From: Laura Gibbons <Laura.Gibbons@arun.gov.uk>
Sent: 22 March 2022 11:23
To: Planning.Responses <Planning.Responses@arun.gov.uk>
Cc: Simon Davis <Simon.Davis@arun.gov.uk>
Subject: RE: Planning Consultation on: P/14/22/DOC

Engineers Comments Regarding Condition 2

Application No: P/14/22/DOC

Description of Works: Approval of details reserved by condition imposed under P/147/21/RES relating to conditions 2-detailed levels survey, 4-in curtilage cycle stores, 5-colour schedule of materials and finishes and 6-energy efficiency.

title: Topographic Survey scale: 1:250@A0

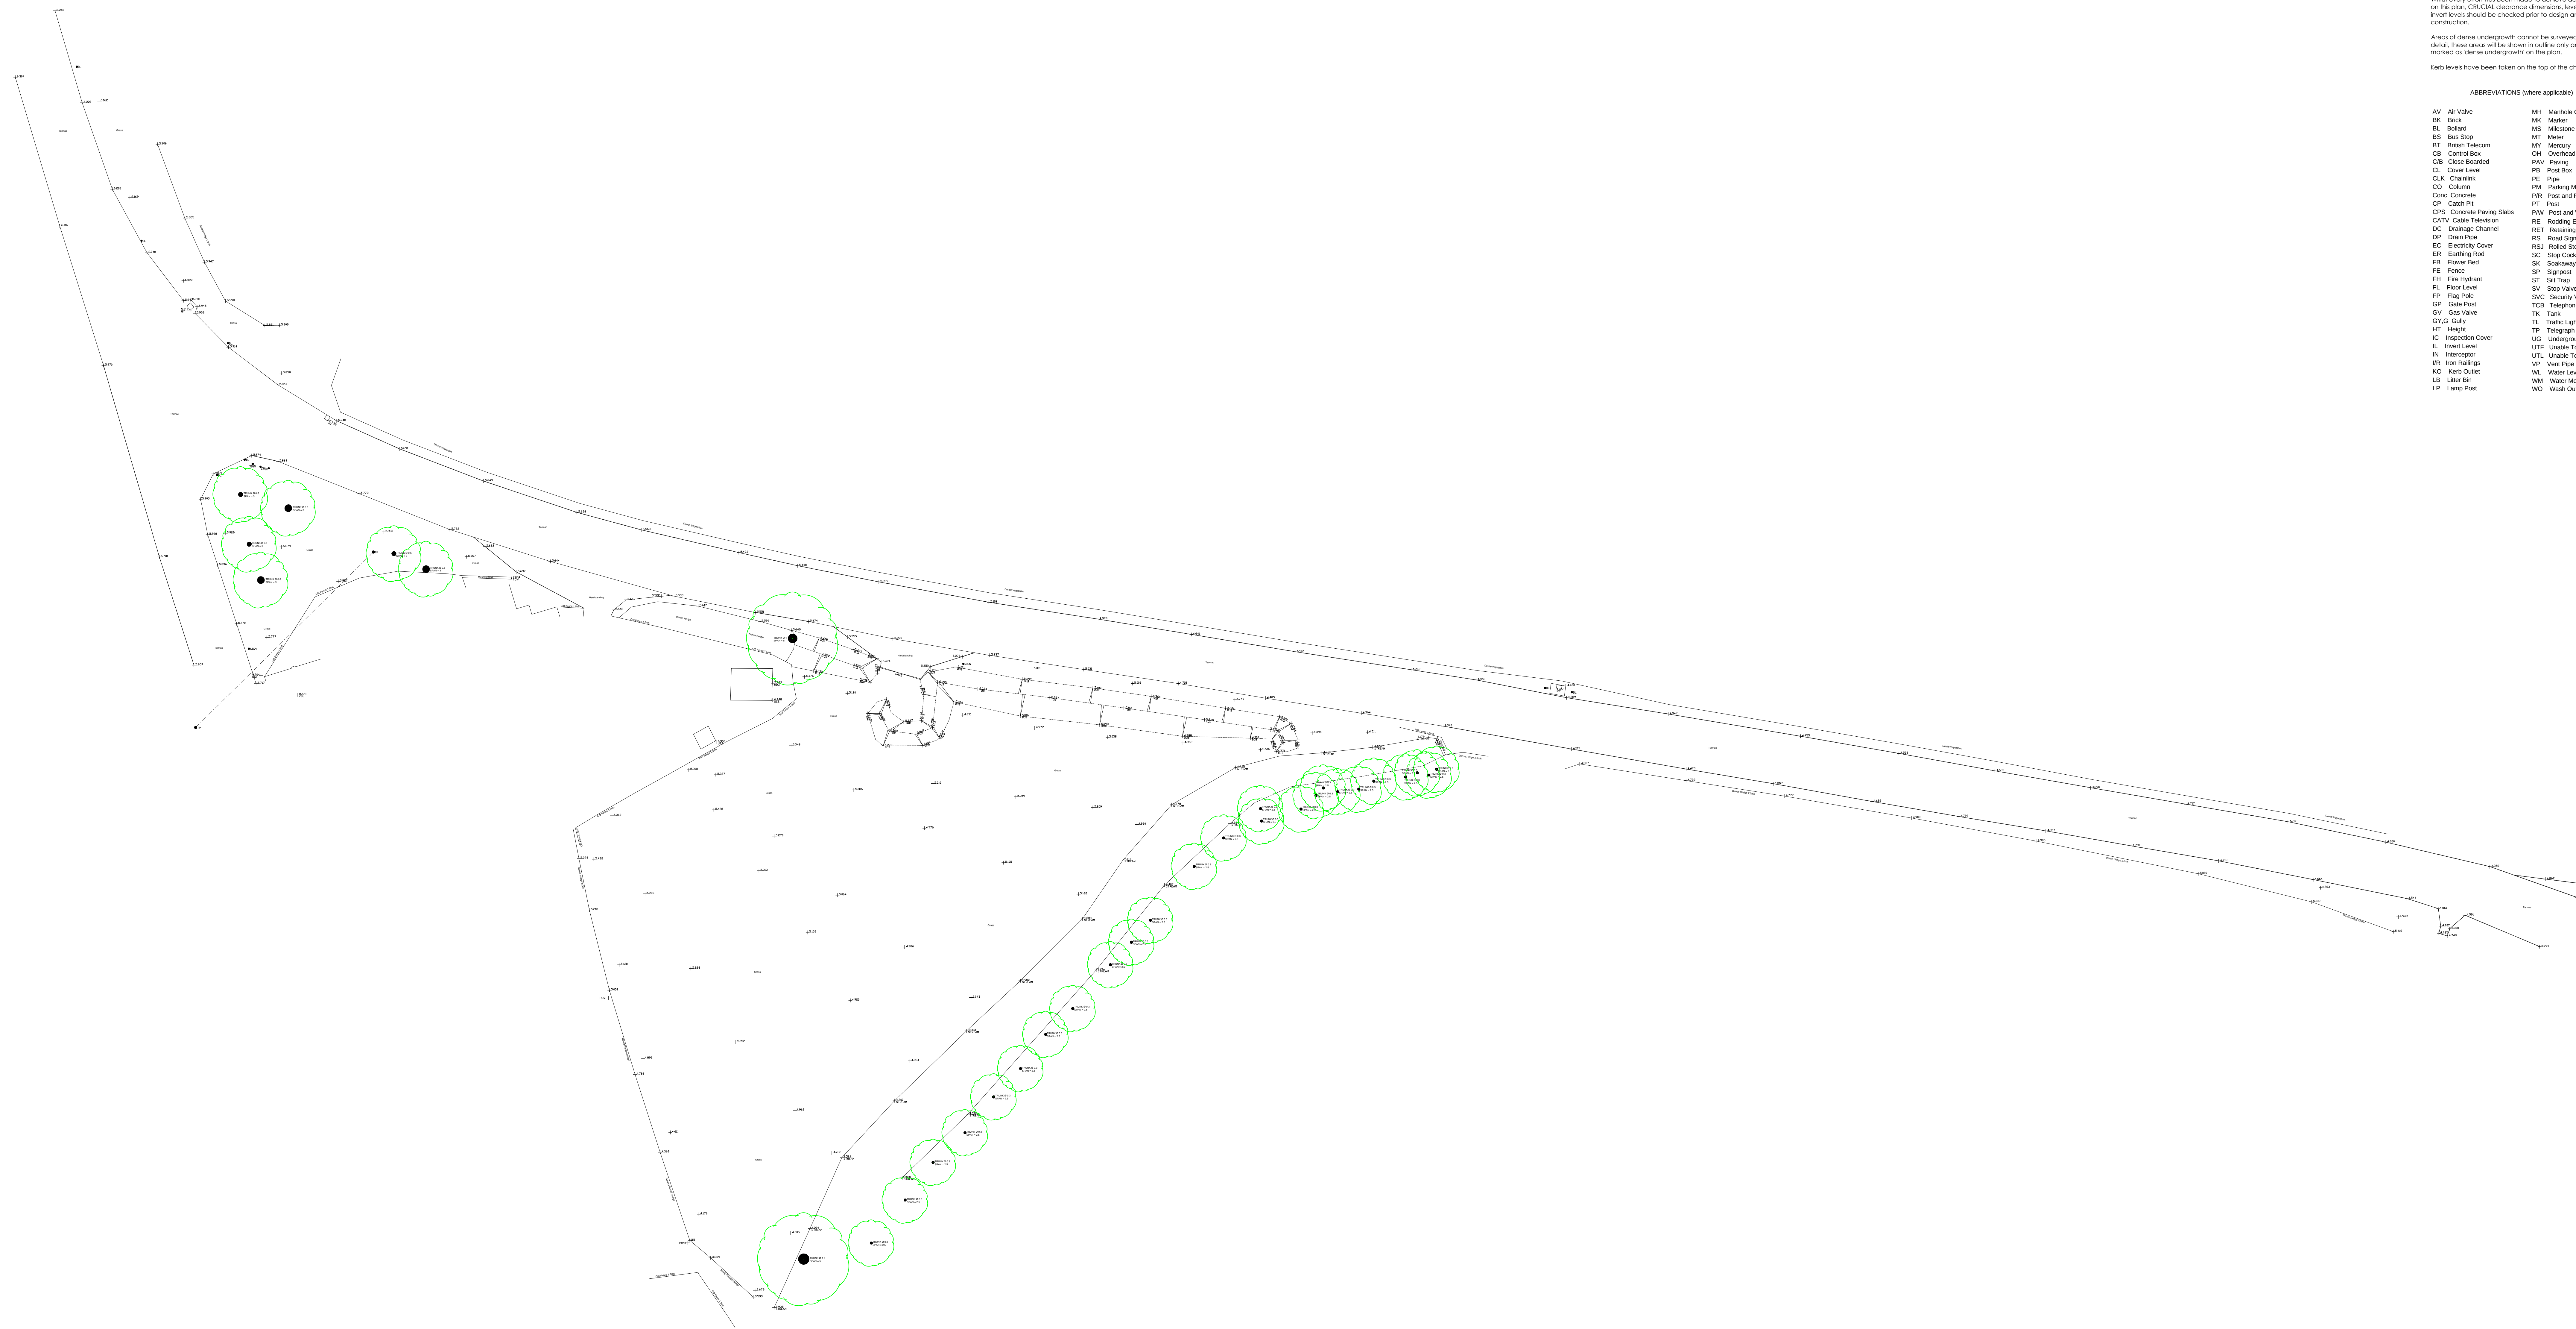
As per our comments on P/15/22/DOC we strongly suggest that the surveyed watercourse levels are checked.
